January 10, 2022

Jeff Rice
El Paso County
PCD Engineering Division

RE: Woodmen Frontage Road / Bent Grass Meadows Dr Turn Lane
Comment Response

EXISTING DRAINAGE MAP
SCALE: 1"=40'

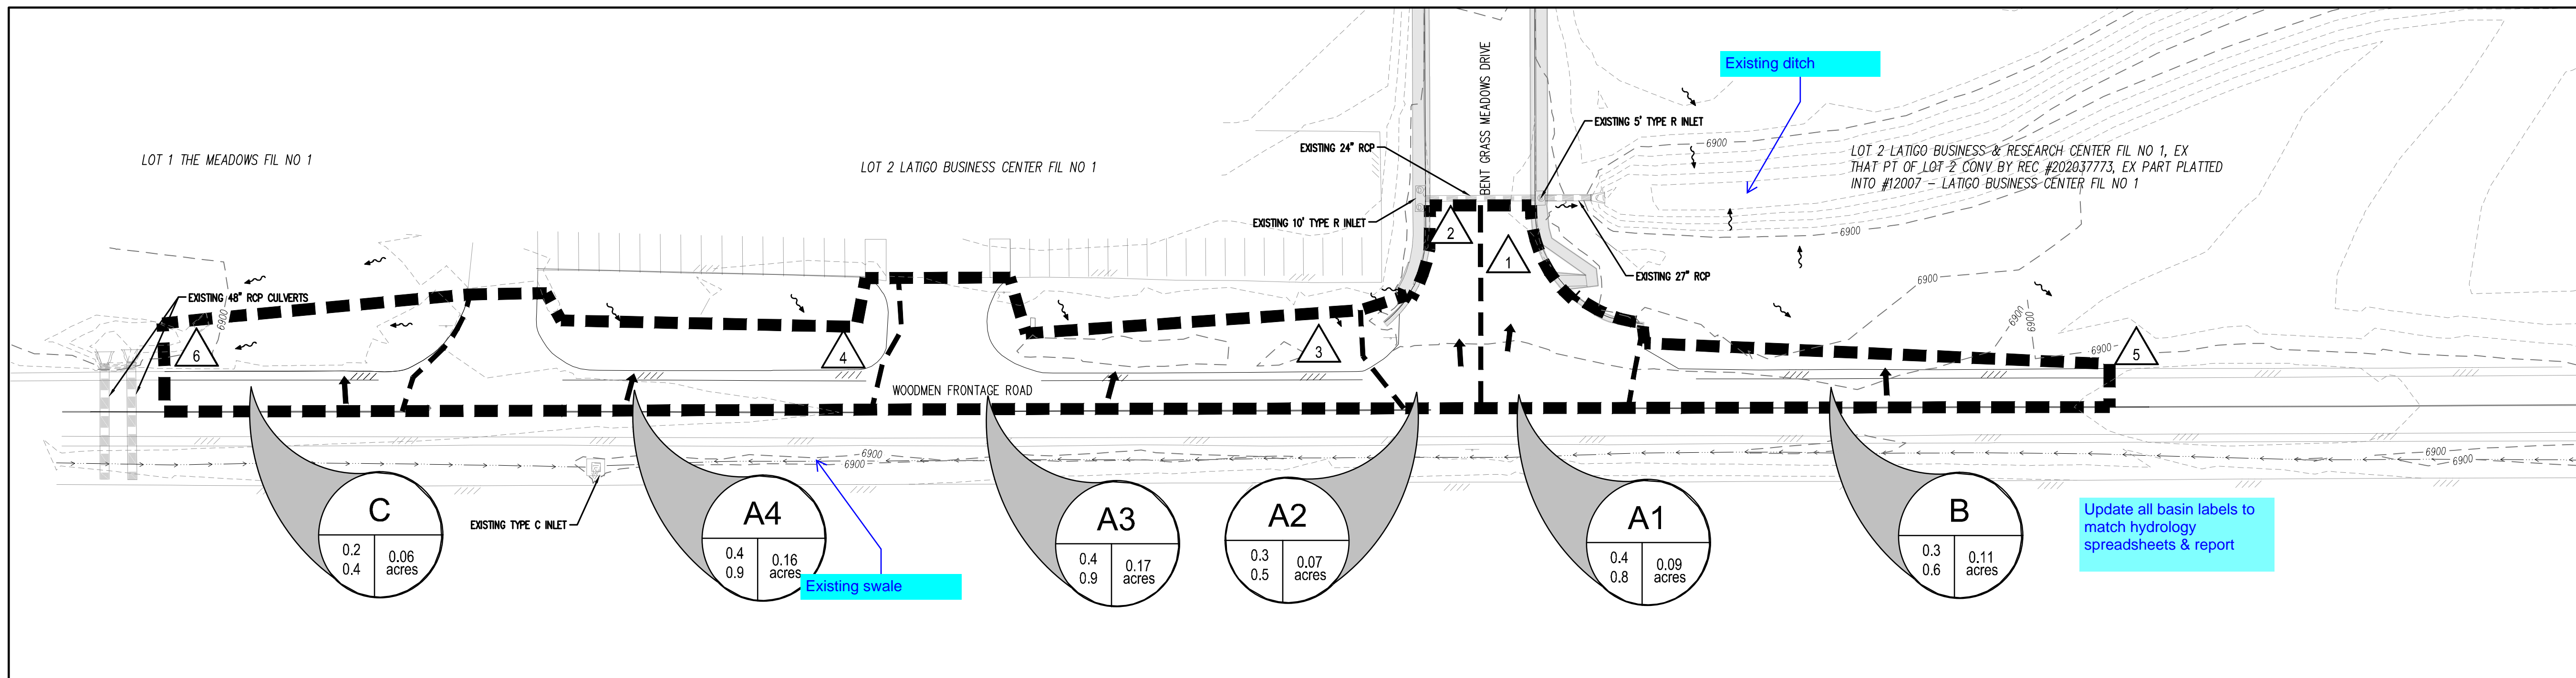
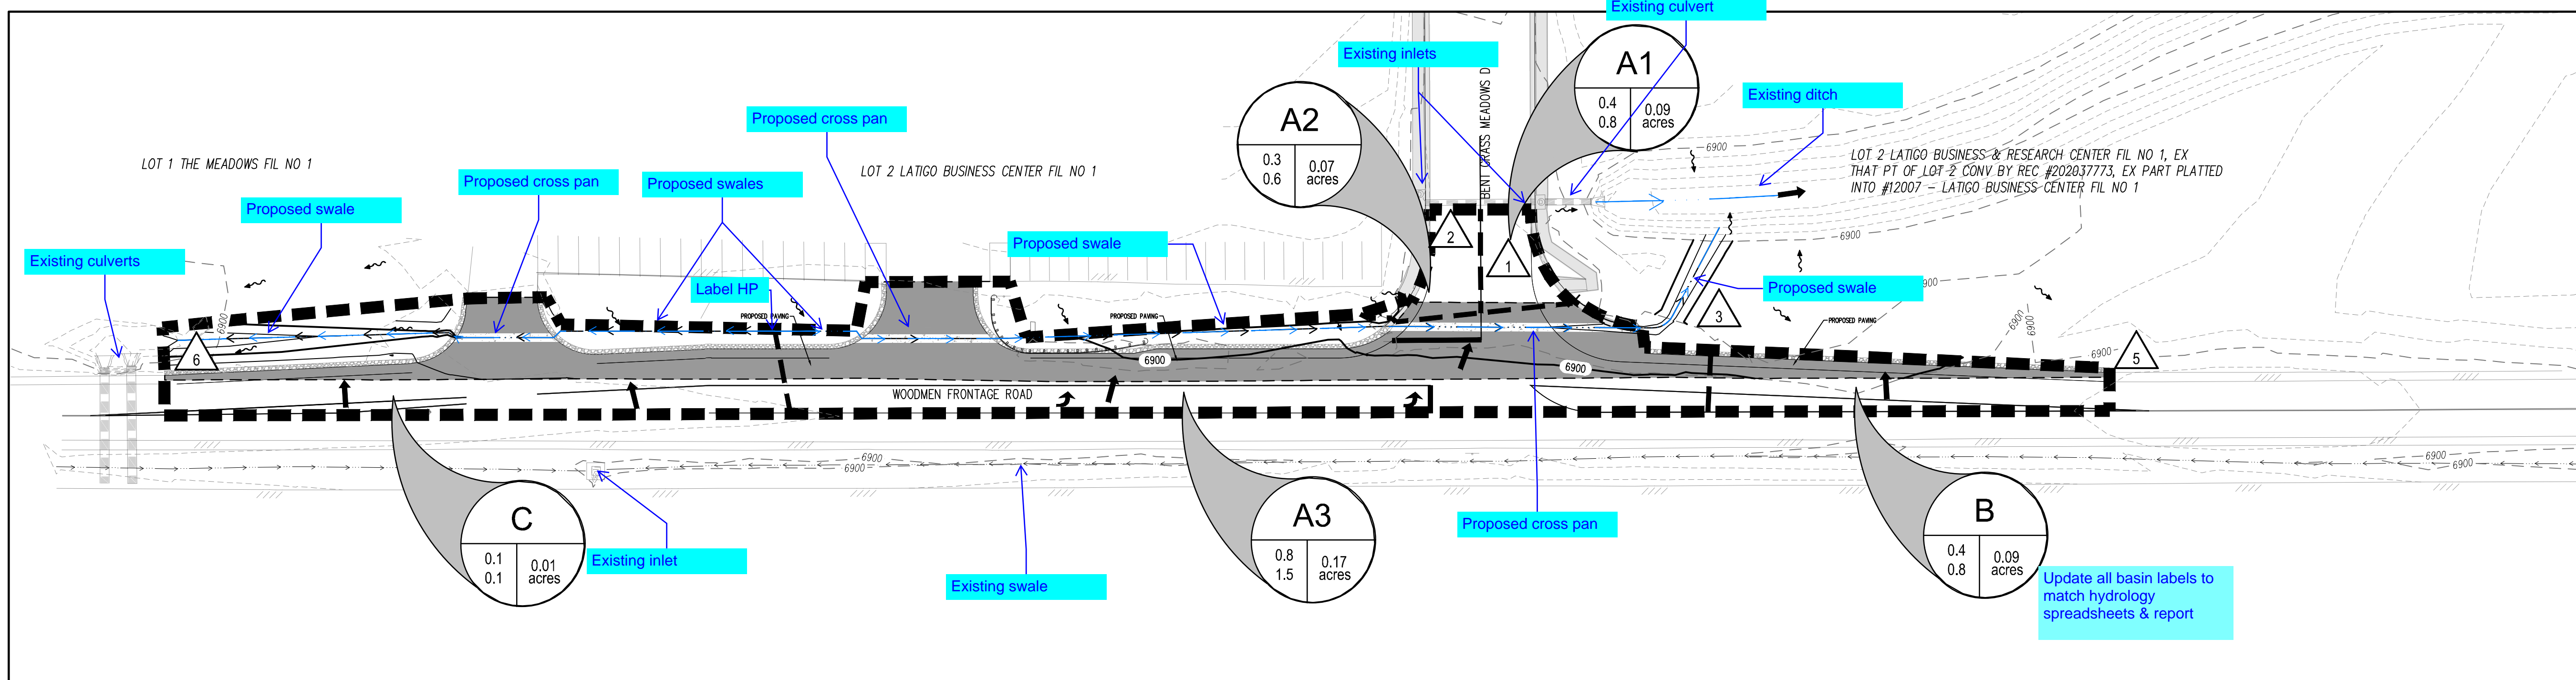
5. The drainage plan needs to show all existing and proposed drainage improvements, details, and downstream conveyance.
Response: We have shown all drainage adjacent to the project site. Also, we added further basin description and downstream storm culverts on the drainage map.
